Subject: Yapton Parish Council Response to Planning Application Y/1/17/OUT - Bonhams Field, Main Road, Yapton, BN18 0DX

Bonhams Field, Main Road, YAPTON

PLANNING REFERENCE Y/1/17/OUT

Appendix B: Proposed Master Plan

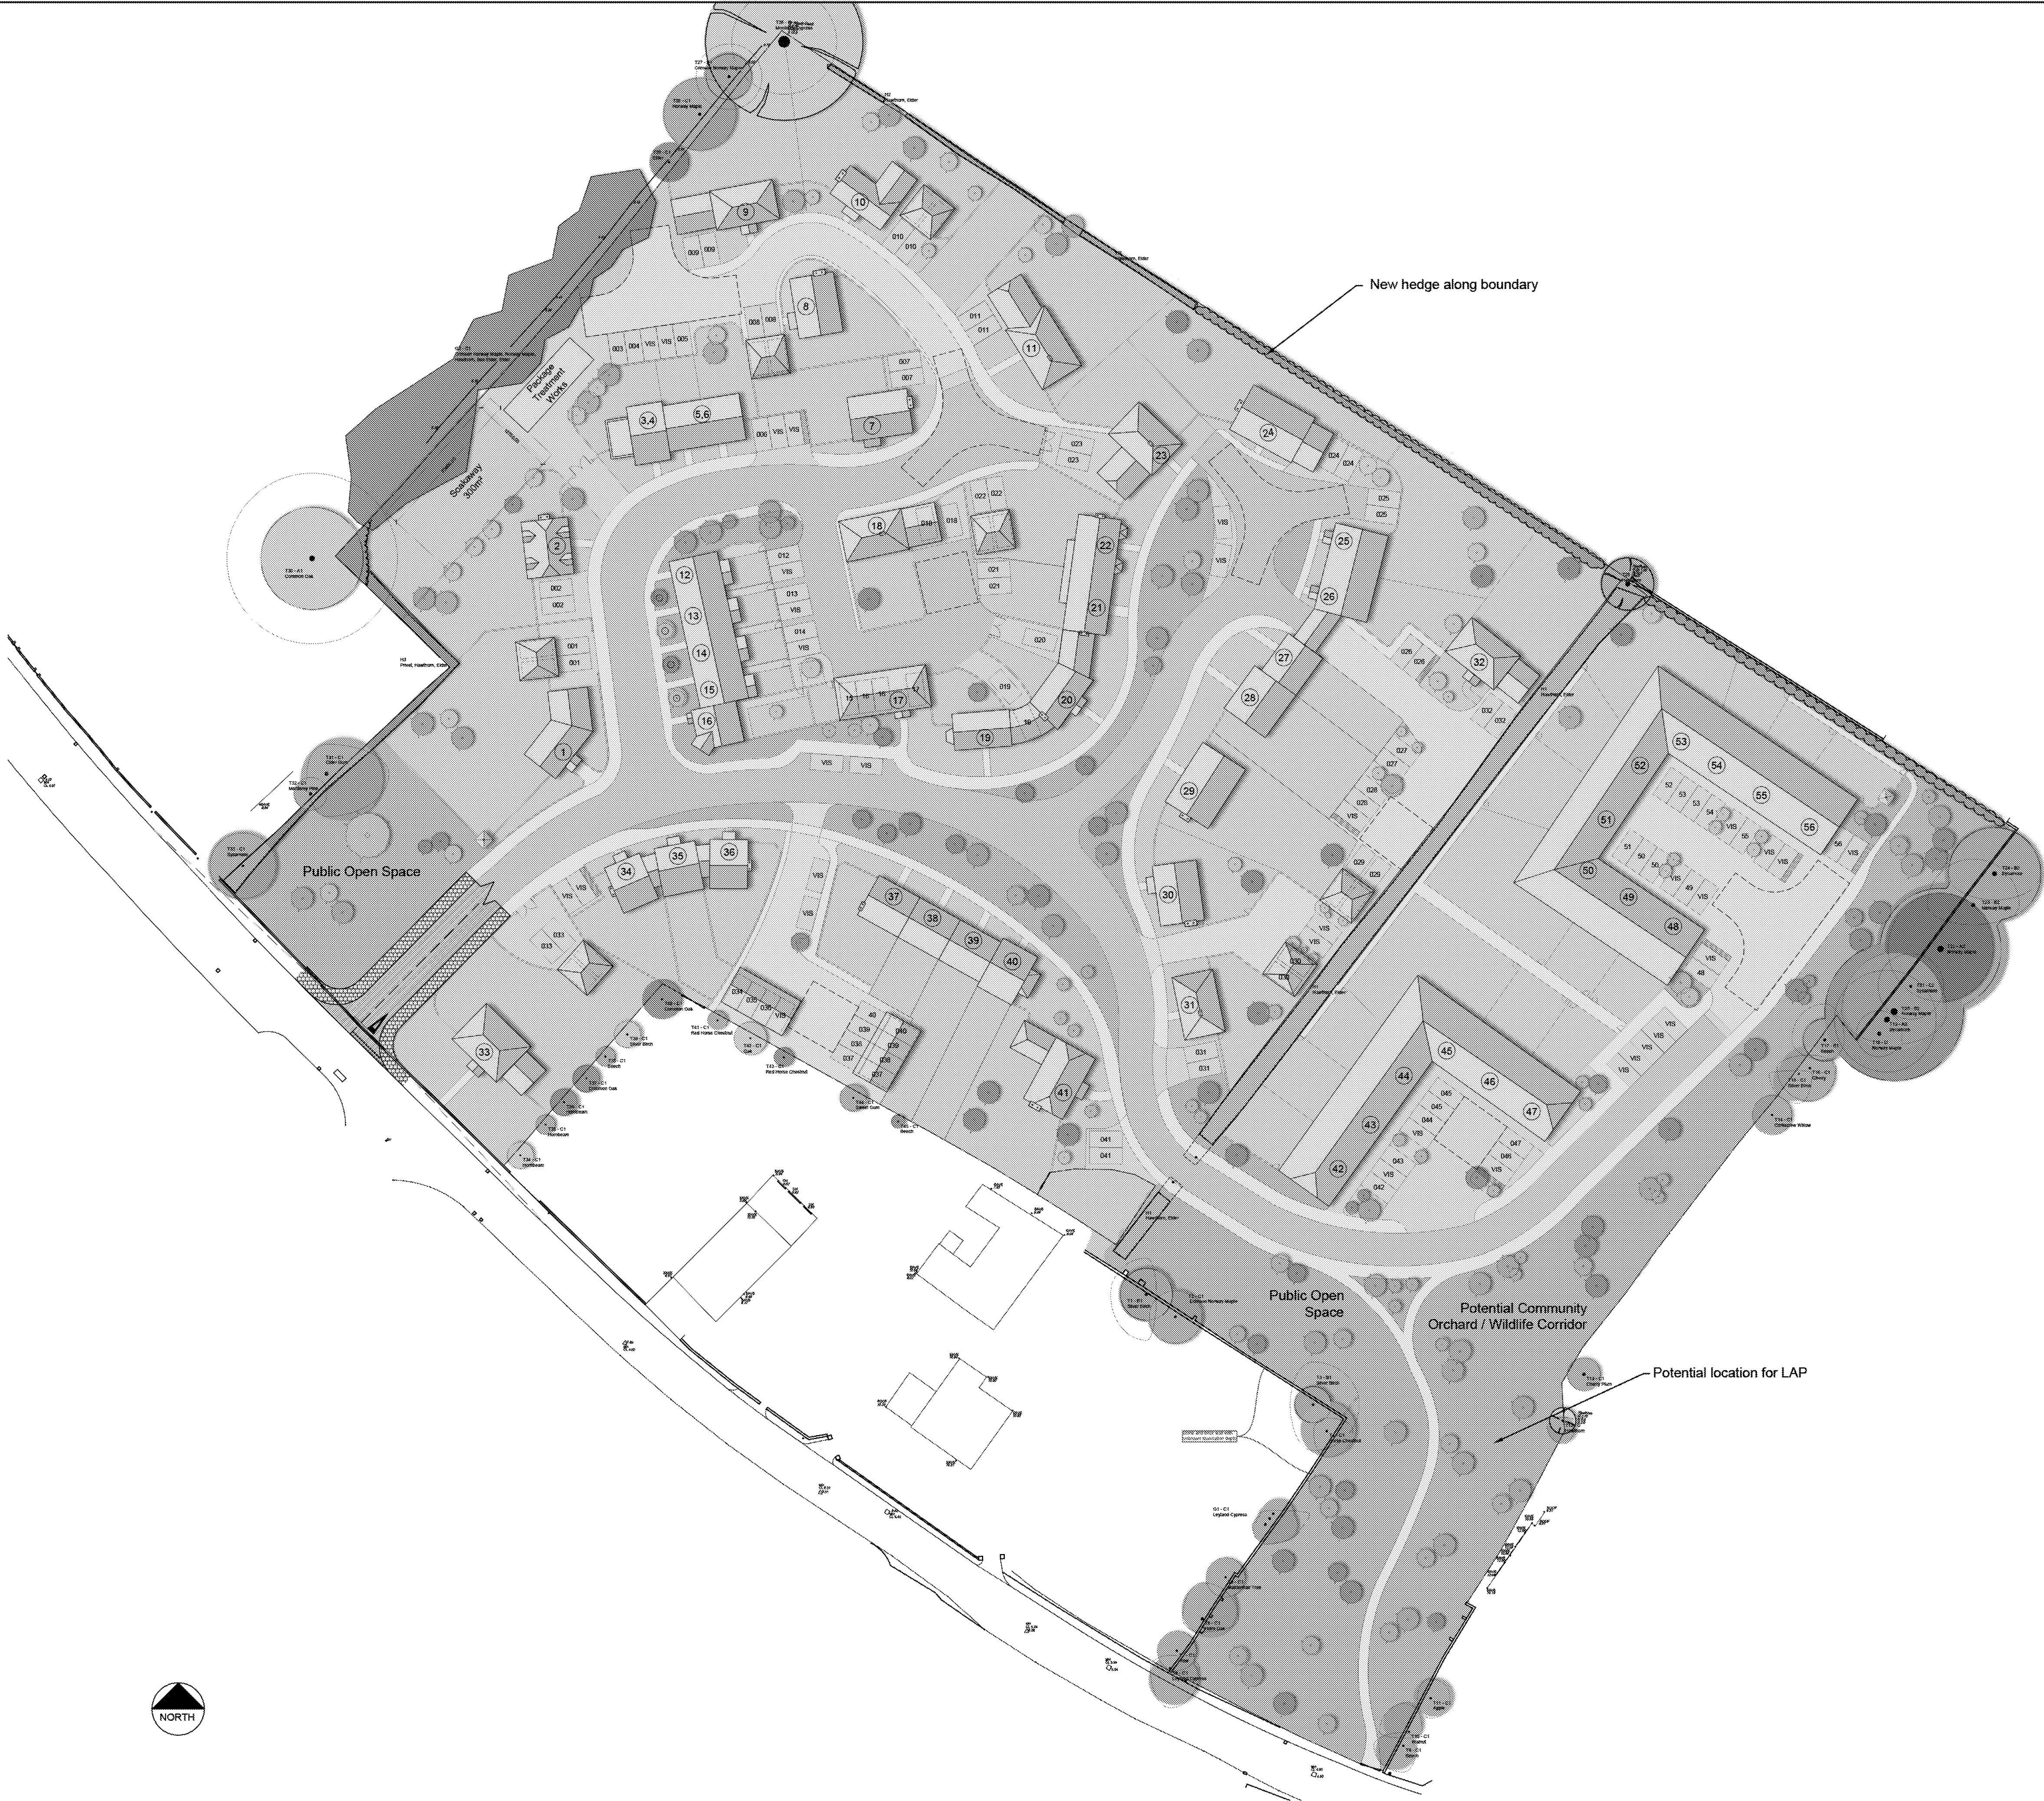
However, the Parish fail to understand how house number 33 blends or enhances the setting of the listed buildings and adjoining Main Road conservation area. The building appears isolated from the main bulk of the proposal and sits in a key area of open space which defines the rural approach to Yapton as well and enhances the historic rural nature of Elms barn.

The Parish would seek to see this area remain open space.
